Item No. **Report of the Head of Planning, Transportation and Regeneration**

Address 26 COPTHALL ROAD EAST ICKENHAM

Development: Single storey garage to front (Part retrospective)

LBH Ref Nos: **10265/APP/2020/3063**

From submitted drawing L.01 (please also see drawing L.02)

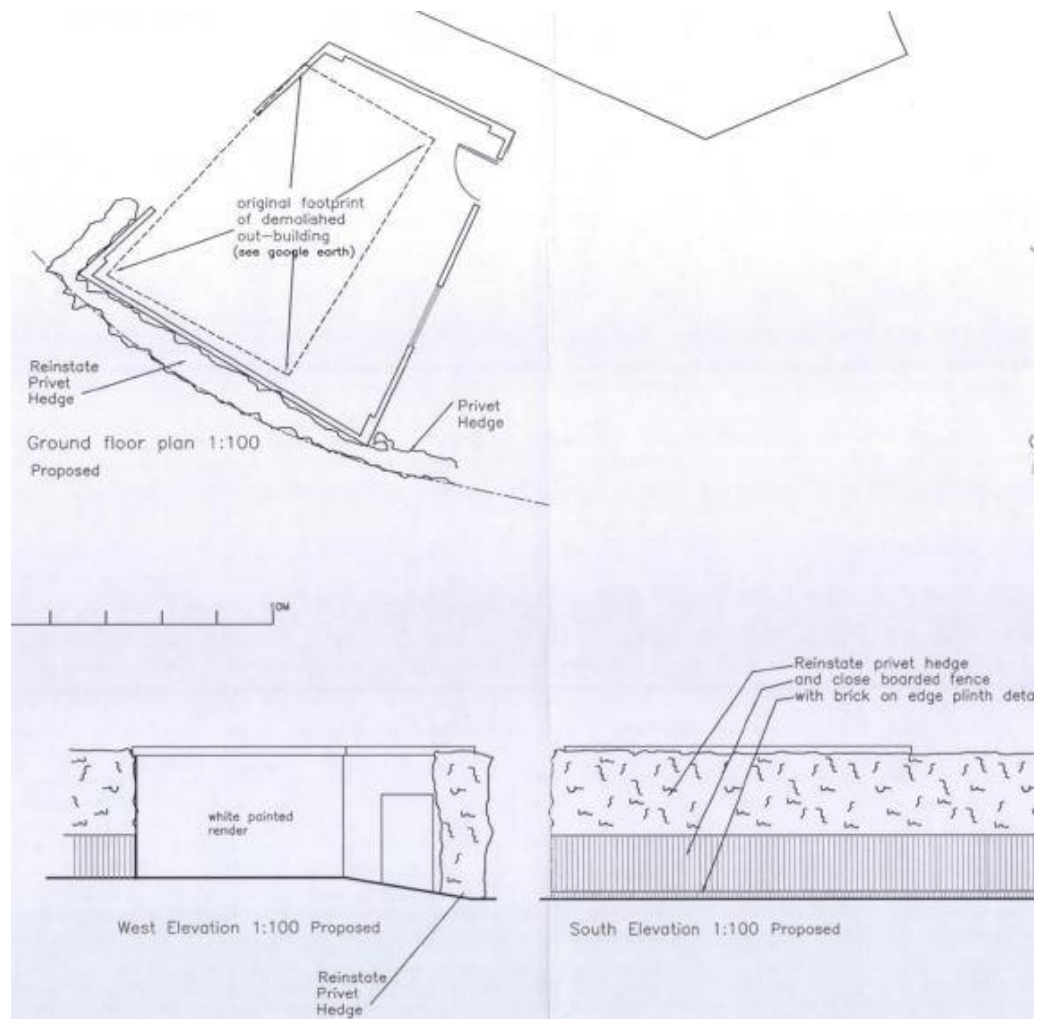
The detached garage is located forward of the existing building. It would essentially comprise a front extension leaving a small gap of approximately 2m between the front elevation of the host dwelling and proposed garage wall. The structure is to be used as a garage, measuring 6 m in depth and between 6 m and 4 m in width. The maximum height of the garage is between 2.2 m and 2.7 m high, with a flat roof. The development is not considered to respect the character of the area especially on this prominent corner plot, and would result in an addition that would create a precedent in the locality.

The proposed garage, by reason of its siting in this open prominent position, size, scale, bulk and height would result in an incongruous addition and would thus be detrimental to the visual amenities of the street scene and the character and appearance of the wider area. The proposal is therefore contrary to Policy BE1 of the Hillingdon Local Plan: Part One - Strategic Policies (November 2012) and Policies DMHB 11 and DMHD 2 of the Hillingdon Local Plan: Part Two - Development Management Policies (January 2020).
